From: Rossi, Steph @ Sydney <Steph.Rossi@cbre.com>
Sent: Thursday, 27 January 2022 10:58 AM
To: Alejandra Rojas <Alejandra.Rojas1@det.nsw.edu.au>
Cc: Spedding, Stephen @ Sydney <stephen.spedding@cbre.com.au>; Carmody, Greg @ Sydney <Greg.Carmody@cbre.com>; Jack Bruderlin (Jack Bruderlin) <Jack.Bruderlin@det.nsw.edu.au>; Lawler, Nicholas @ Sydney <Nicholas.Lawler@cbre.com>; Chris McGillick <CMcGillick@ethosurban.com>; Ella Coleman <EColeman@ethosurban.com>
Subject: RE: RFI - DPIE further comments

1. *The Department previously requested details of internal layout of Childcare Centre and internal play spaces. This information has not been provided. Please submit amended plans with the internal layout with test fit concept plan to demonstrate compliance with the required play area for 40 preschool children.*

Drawing Reference
NLPS-AR-DRG-0203
Revision
P3

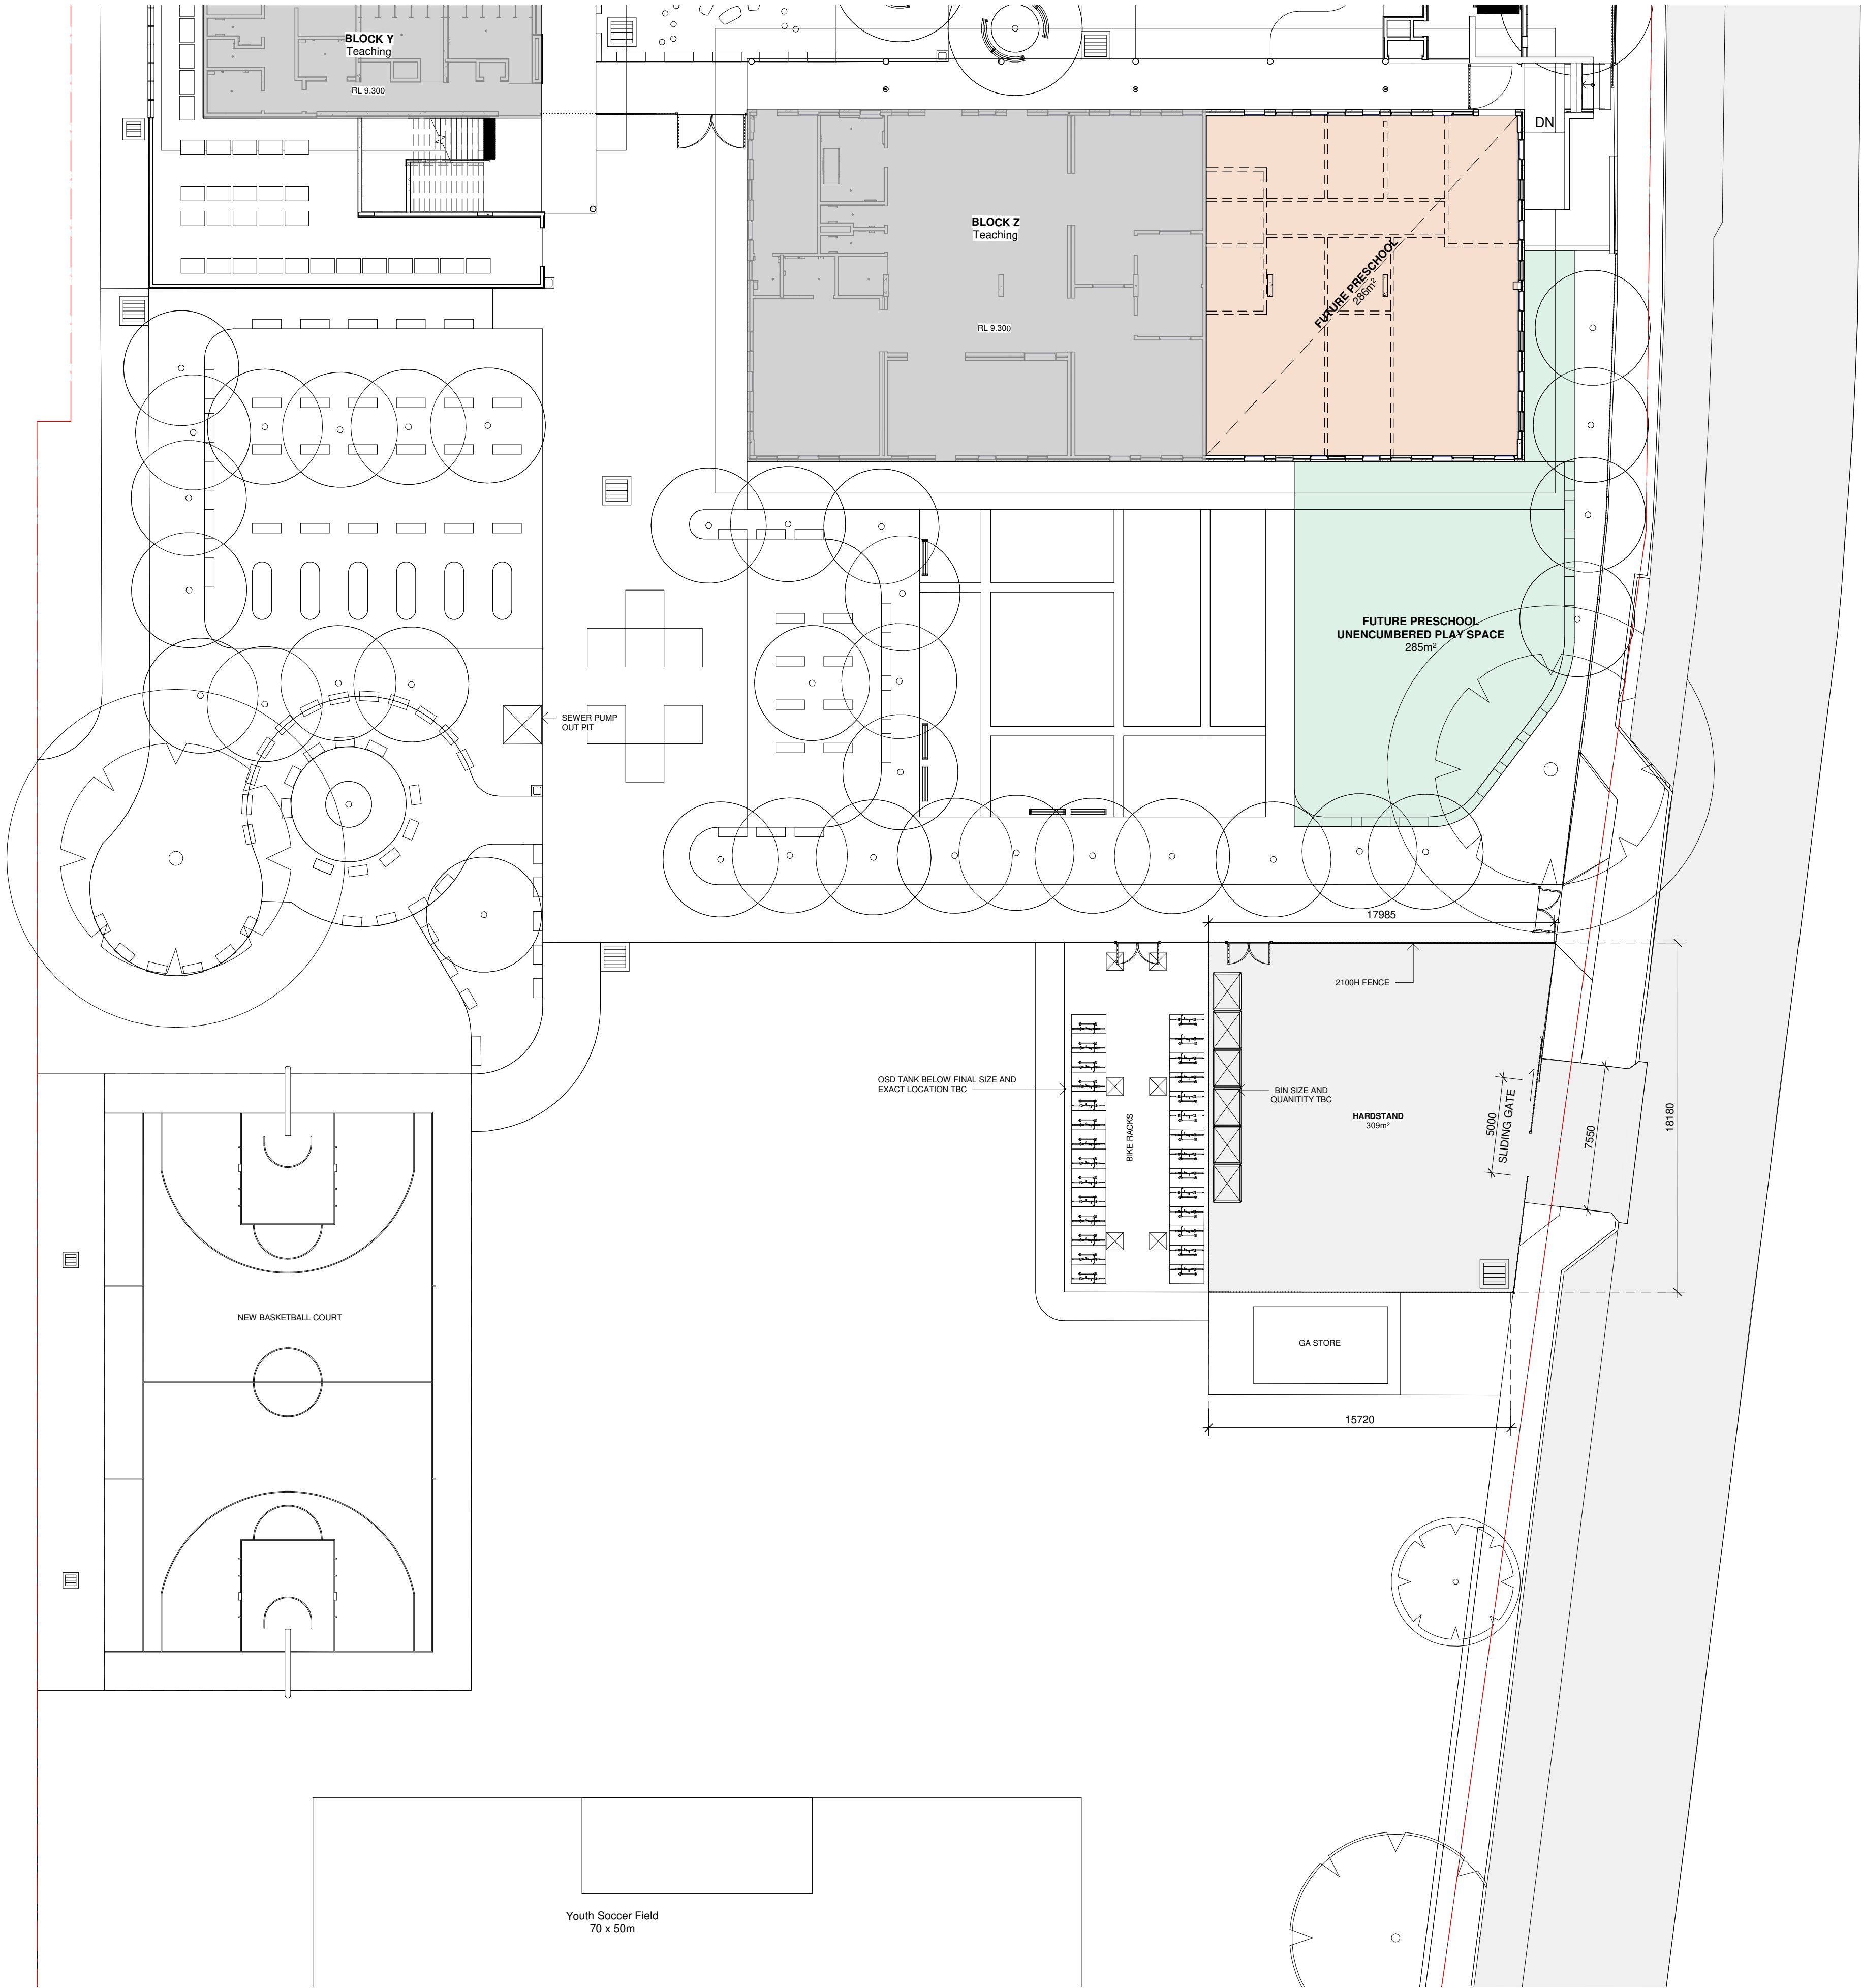
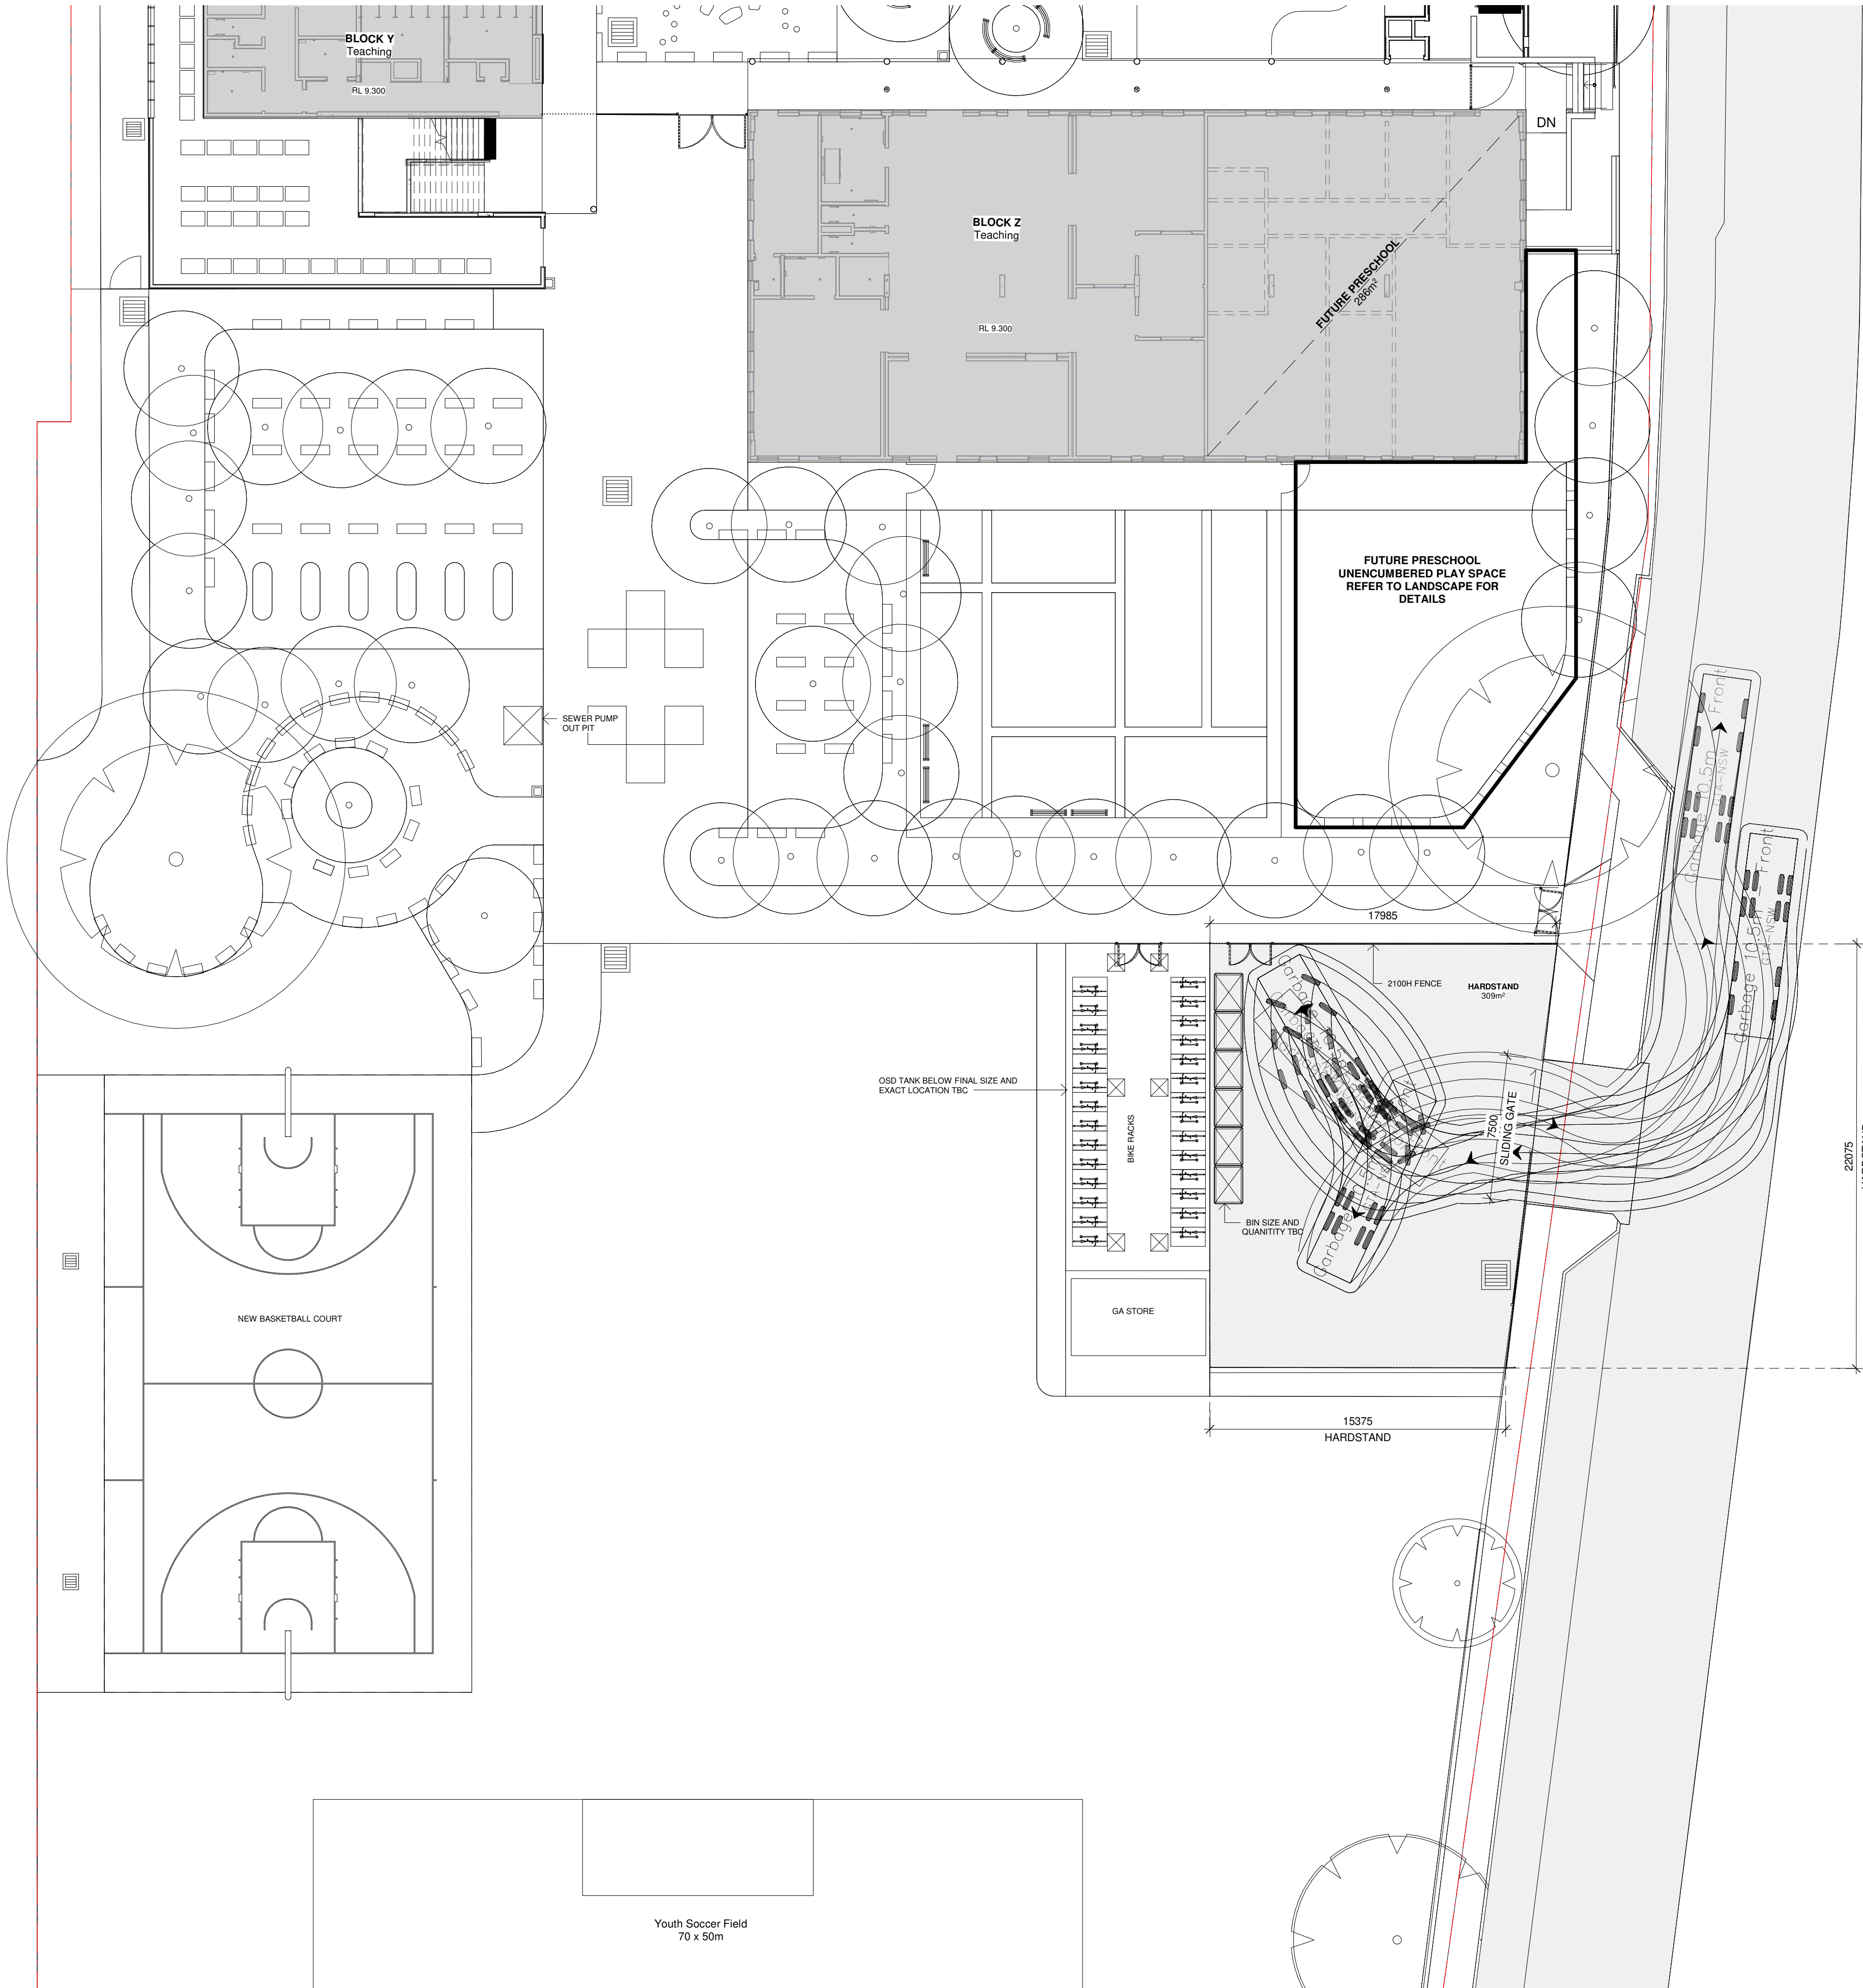
2. *The submitted drawing no NLPS-AR-DRG-0203 showing unencumbered play area for childcare centre in a narrow strip and the drawing no NLPS-LA-SSD-3600-DRG showing the trees planting/landscaping on the play area. The narrow strip is not suitable for play for the children. Amended drawings are required to show the proposed/future childcare centre complies with the State Environmental Planning Policy (Educational Establishments and Child Care Facilities) 2017 (Education SEPP) and the Department's guidelines.*

3. *The submitted drawing no NLPS-AR-DRG-0203 shows the manoeuvring of MRV vehicle's turning path. The Department notes that the allocated hardstand space is not sufficient for MRV manoeuvring and that the MRV would encroach into the waste area. Please address this issue and relocate/resize the hardstand area or relocate the vehicle turning circle area to allow for adequate manoeuvring of MRV within the site.*

Refer to **ATTACHMENT B**, showing the amended play area excluding the narrow landscaped zone, achieving the required play area for the future preschool.

Refer to **ATTACHMENT C**. The bin storage area and surroundings have been reconfigured to show the bins to the south of the hardstand and therefore provide increased manoeuvrability for a medium rigid vehicle. The bins and bin wash area have been shown on the plan in accordance with the requirements of the Waste Management Plan.
